170 Slater Street

Urban Design Review Panel Recommendation Responses 170 Slater Street

**RE: Urban Design Review Panel Recommendation Responses
PC2023-0379
170 Slater Street – Site Plan Control**

FLOOR PLAN LEVEL 2 (1:250)

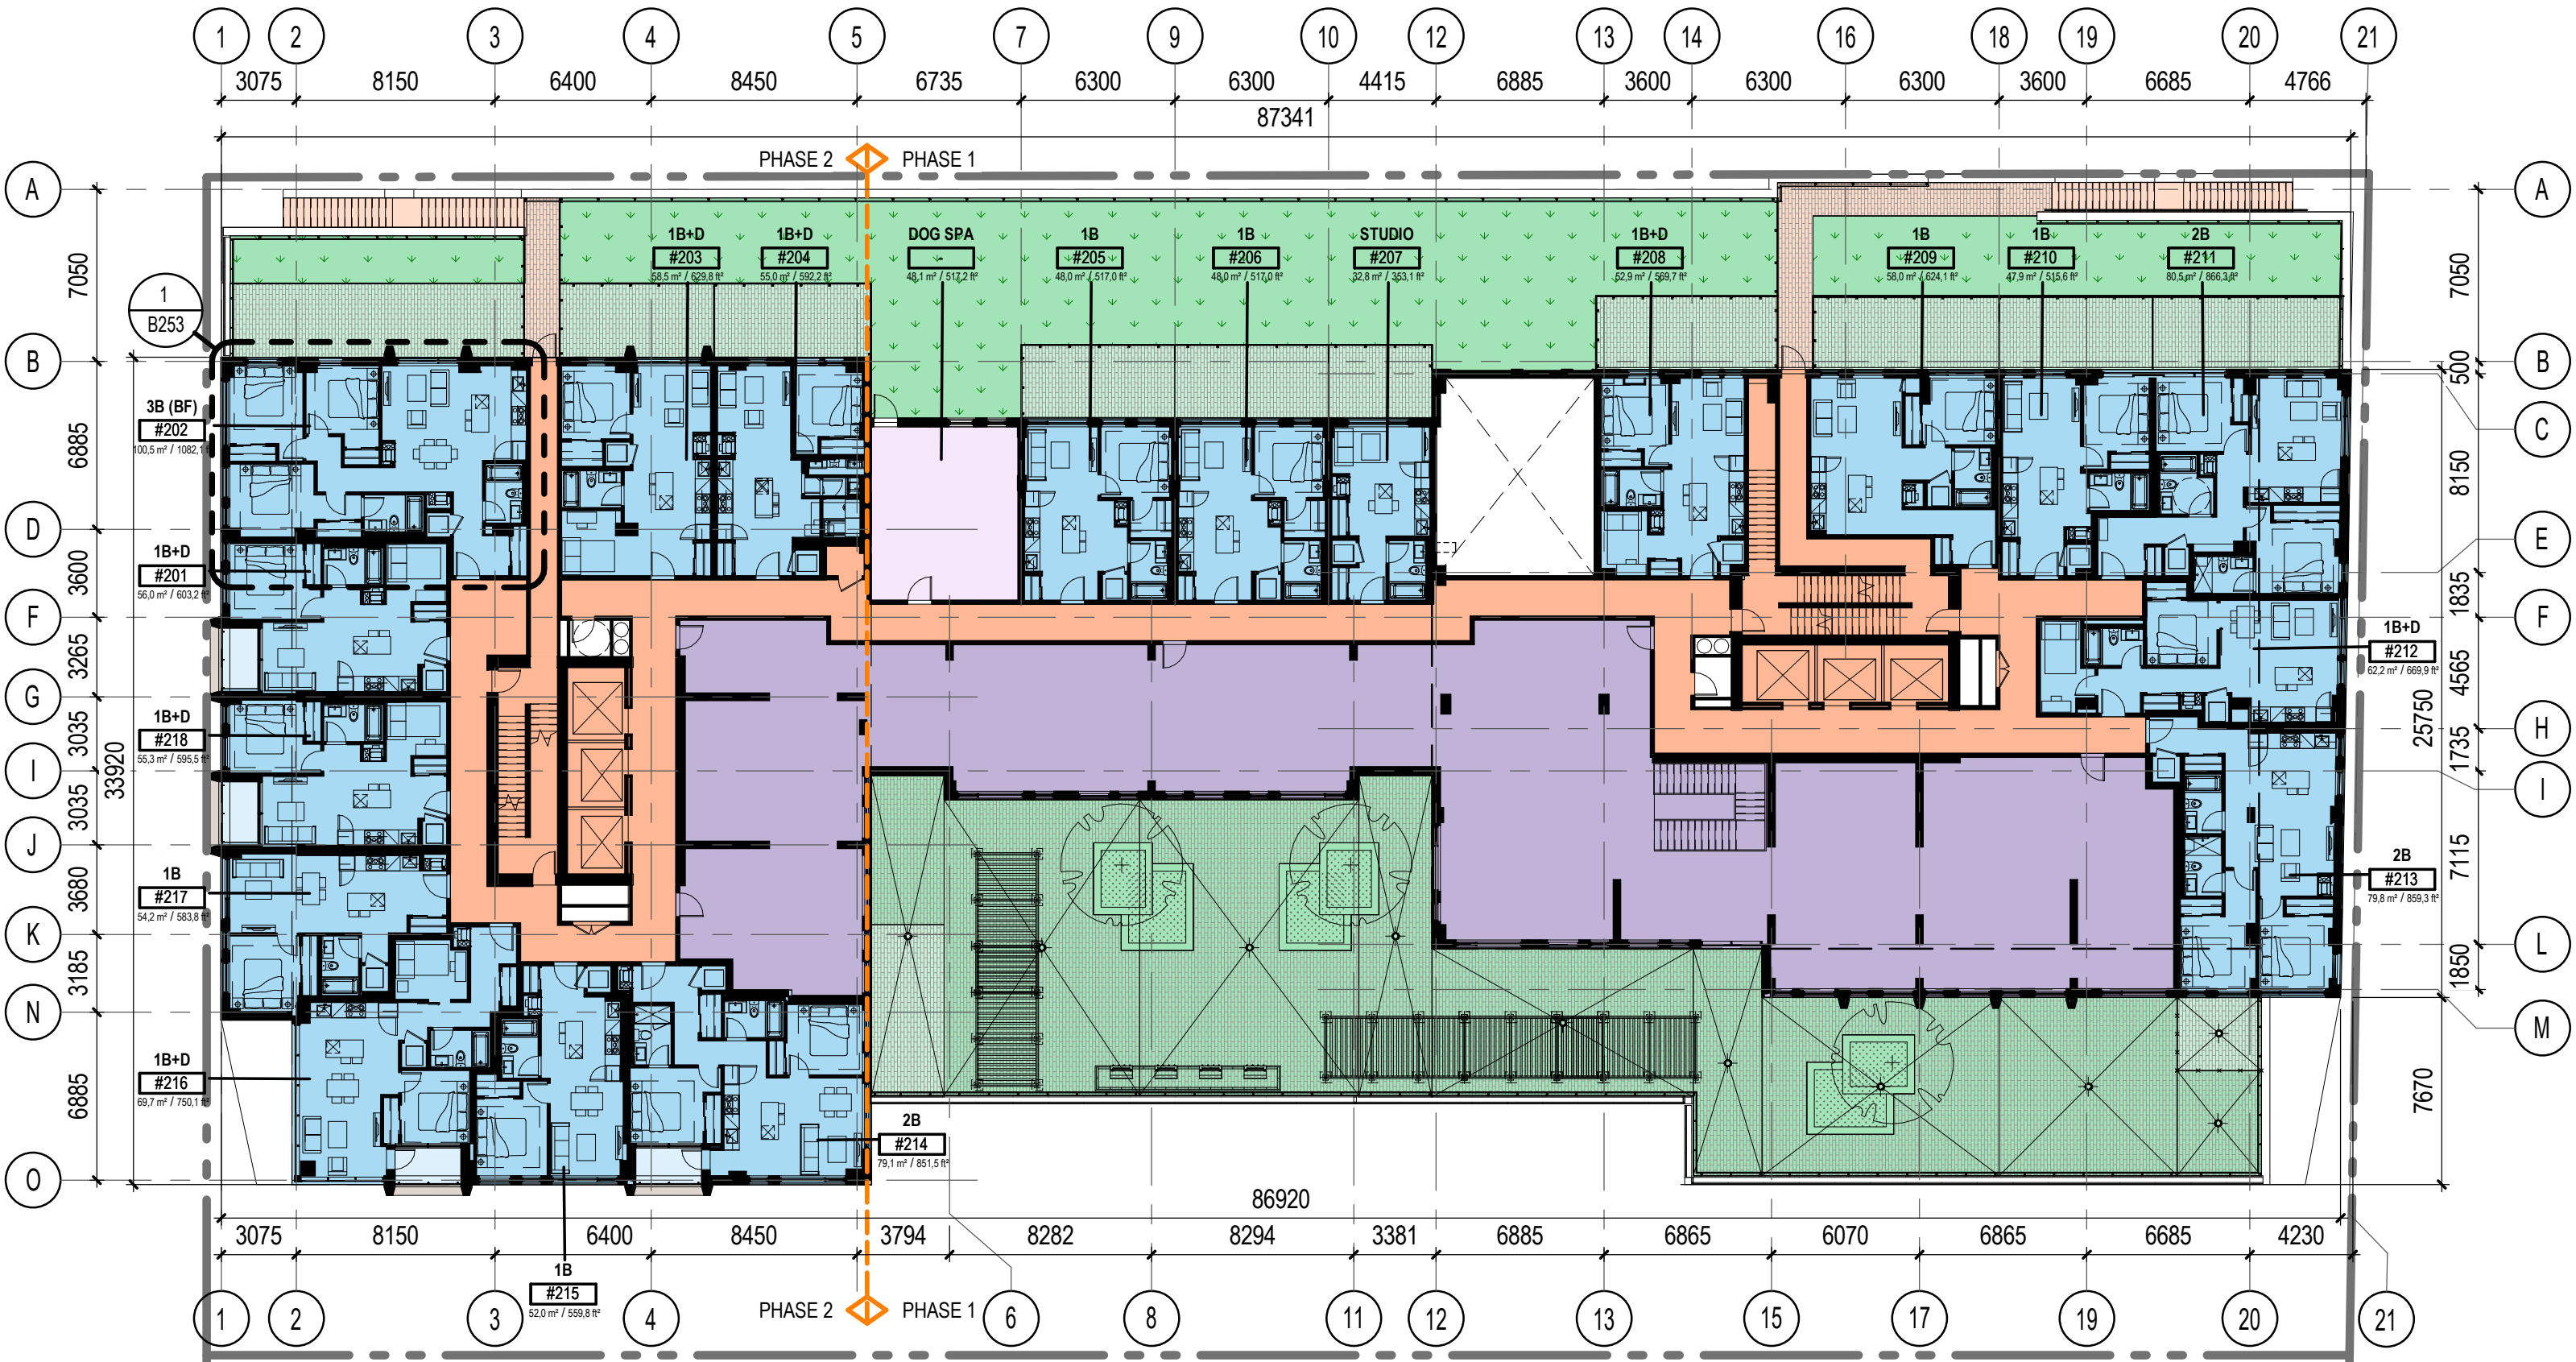
- 15 The Panel has concerns with the location and amount of amenity space. According to the shadow studies, the rooftop amenity spaces at 2nd level have very little sunlight, even in the mid-June period.

Noted.

Proposal for the north side facade in the interim period between phase 1 and phase 2 - final design to be determined

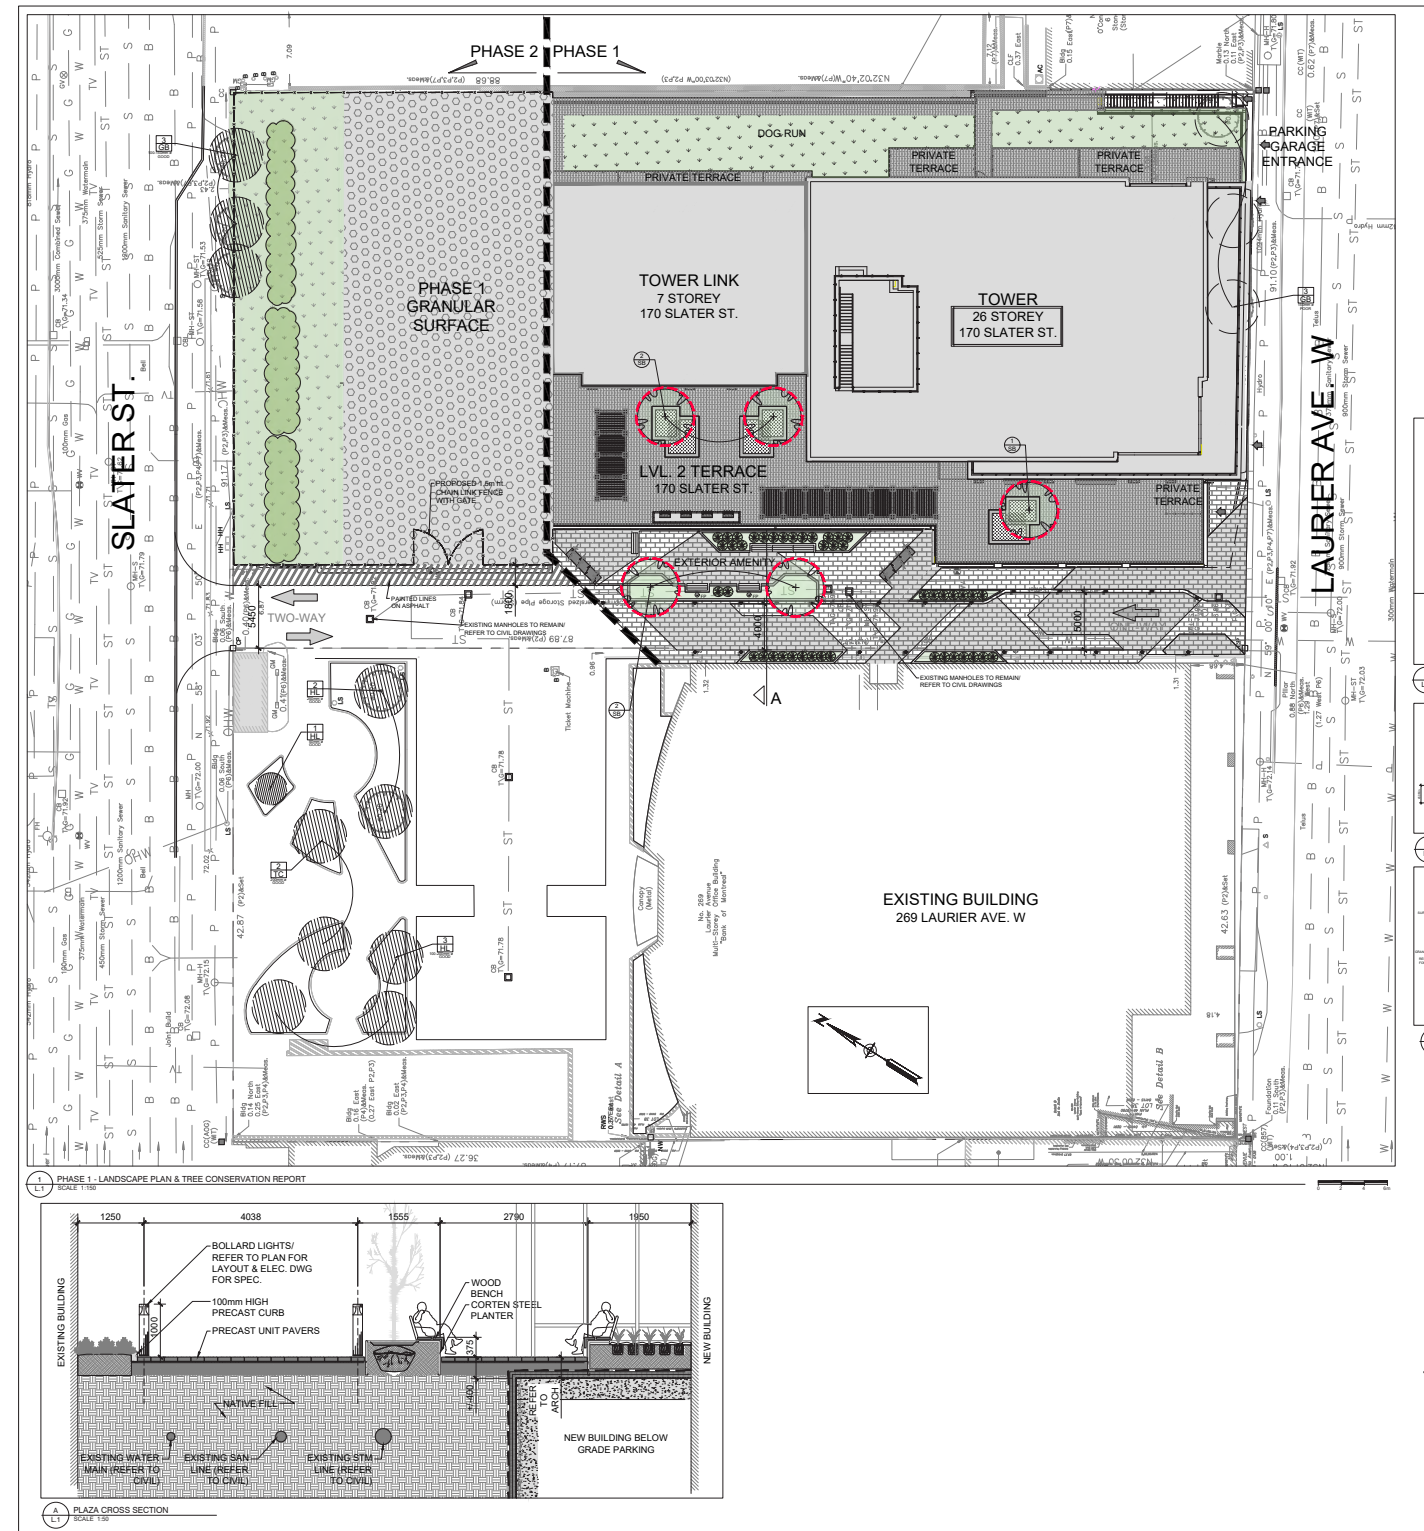
- 8 The Panel recommends carefully considering the interim period between the first and second phases of development in terms of how interim facade conditions and the at-grade areas are treated/animated.
 - / Consider a phasing strategy that enhances the spaces in the interim, such as having an art wall on the north side and a temporary POPS.
 - / Consider options other than surface parking for the interim landscaping phase.
 - / The Panel supports the idea of adding a large mural, that idea would mesh well with a public open space.

Please see the accompanying updated Site Plan, which identifies the proposed interim condition for the undeveloped area, prior to Phase 2.

Zoom - Ground floor vehicular access from Laurier

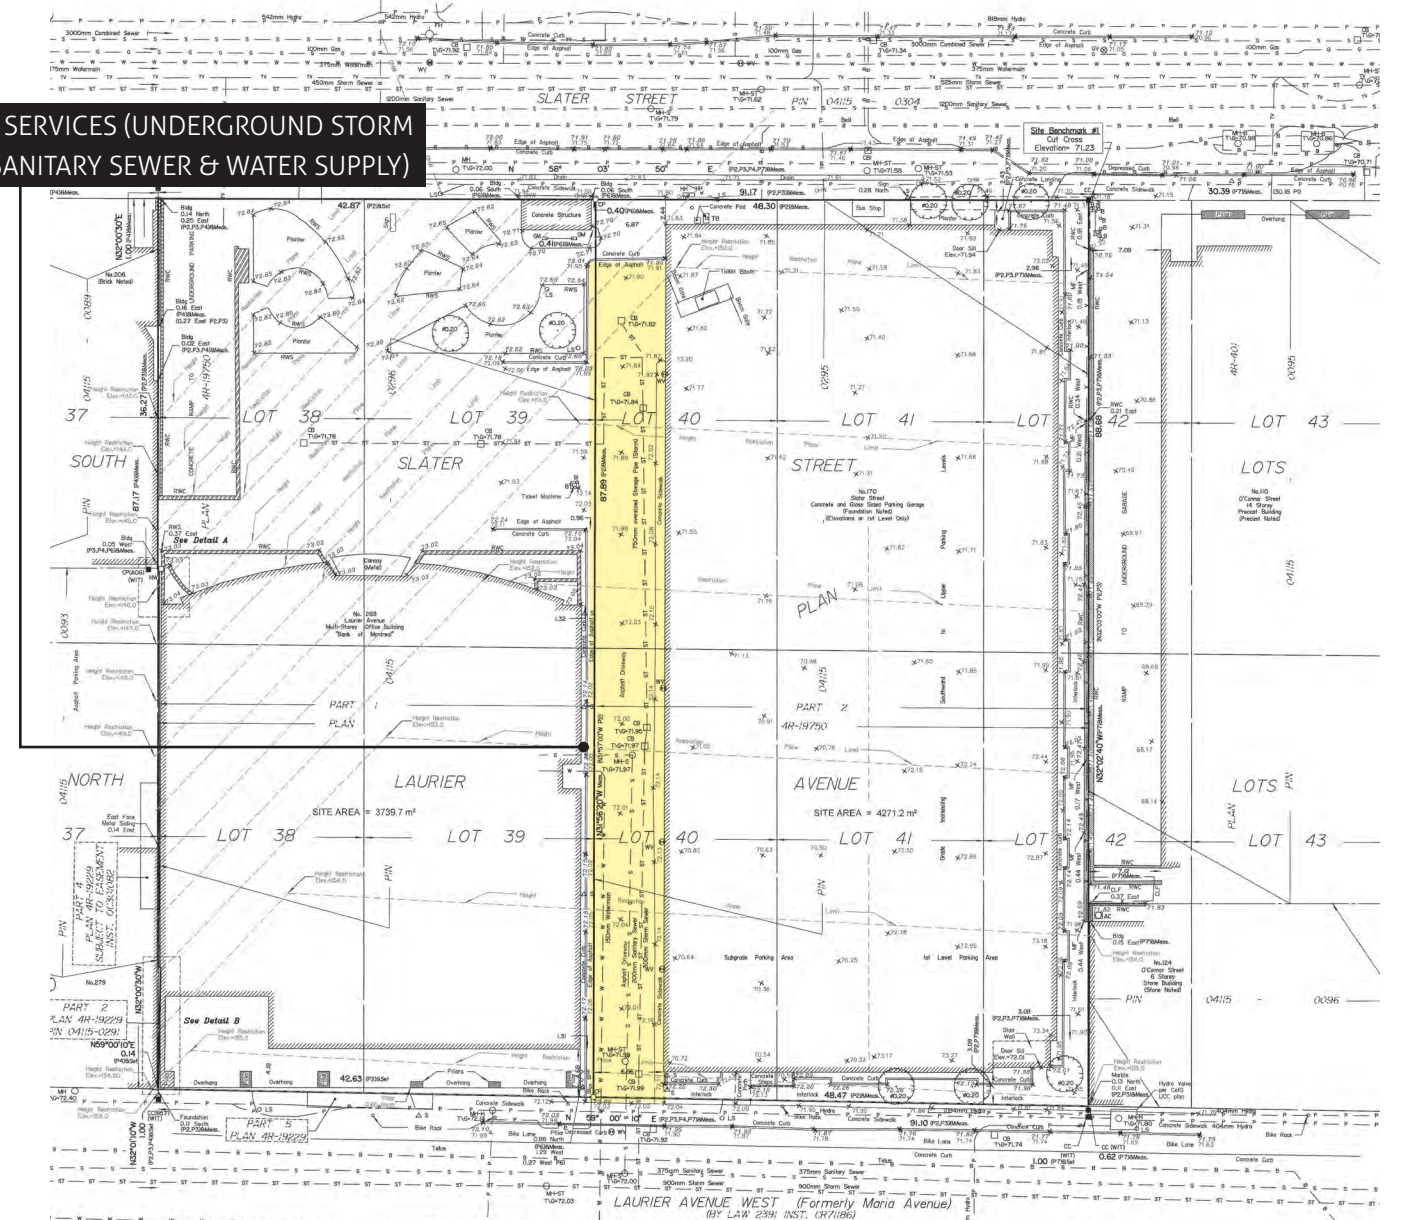
- 10 The Panel has concerns with the vehicular entrance from Laurier Avenue and its interaction with the existing westbound bike lane.
- / Consider sharing the existing parking ramp with the adjacent building and consolidating them as a single vehicular entrance to minimize curb-cuts and reduce intersections with the bike lane.

Noted.
